Consultation Response from: KC Environmental Health (Pollution & Noise Control)		
2021/93689 Land to the south of, Ravensthorpe Road / Lees Hall Road, Dewsbury		
Hybrid application for full planning permission for engineering works, drainage and utilities connection for the provision of site access from Forge Lane and Ravensthorpe Road and associated works; and for outline permission for erection of residential development and mixed use development (including community facilities) with associated works including the provision of internal estate roads and parking, landscape works (including provision of public open space, tree clearance/replacement/woodland management and ecological management) and sustainable urban drainage works drainage principles		
Date Responded: 2nd February 2022	Responding Officer: Rebecca Muff – Air Quality Natalie Heaney – Contaminated Land Mohammed Nasim - Noise	Responding Ref: WK/202134212

The application is for a mixed-use development with up to 350 dwellings including community facilities and associated works. The site forms the first phase of the Dewsbury Riverside allocation (Local Plan ref: HS61) which has been identified by the Council to deliver 4

Figure 2 Noise sensitive receptor locations

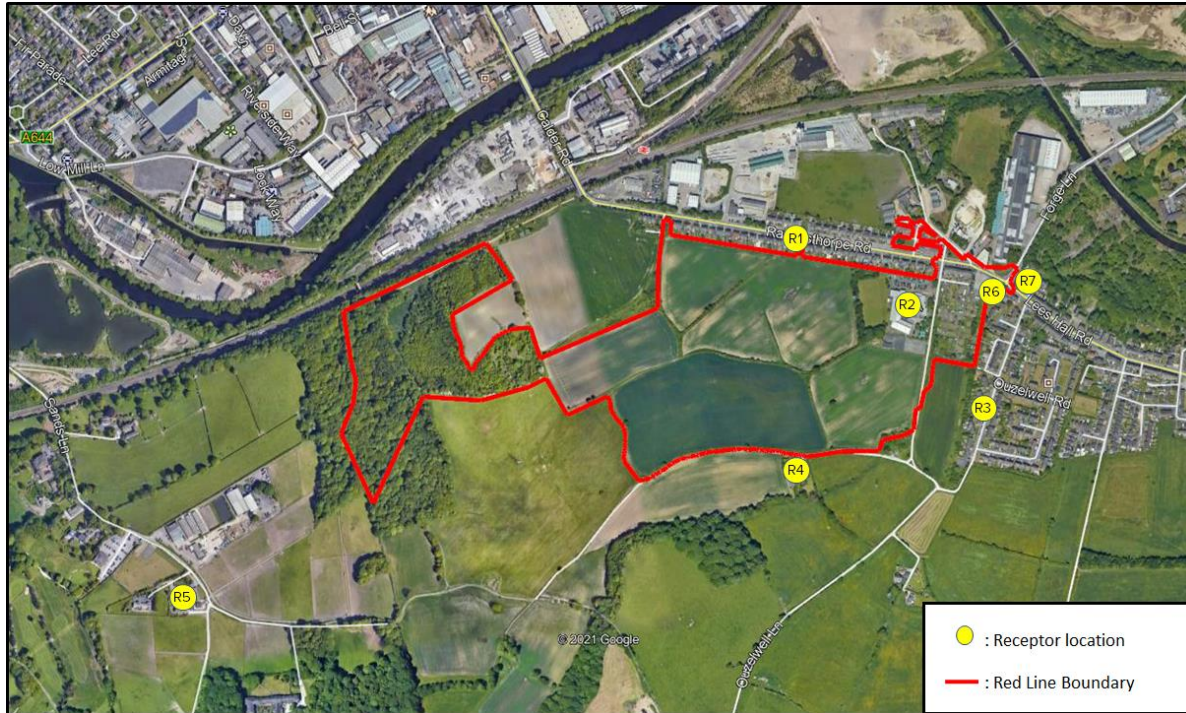
Para 4.2 makes reference to the nearest noise sensitive receptors which have been used in the assessment of the likely effects of noise and they are listed in Table 2 (below) and shown in Figure 2.

Receptor	Noise Receptor Type	Description
R1	C & T	Dwellings on Ravensthorpe Road
R2	C & T	Ravenshall School
R3	C & T	Dwellings on Ouzewell Lane
R4	C & T	Isolated Farm House south of site
R5	C	'Five Arches' on Sands Lane
R6	C	410 Lees Hall Road
R7	T	535 Lees Hall Road
C = Construction T=Traffic

Receptor R6 has been selected primarily to assess the effect of the proposed demolition works at the neighbouring Abu Bakr Mosque and Lees Hall Playgroup building. Receptor R7 is located on the corner of Forge Lane and Lees Hall Road, and has been selected, as the only residential receptor on Forge Lane, to assess the effect of road traffic noise on that road link.
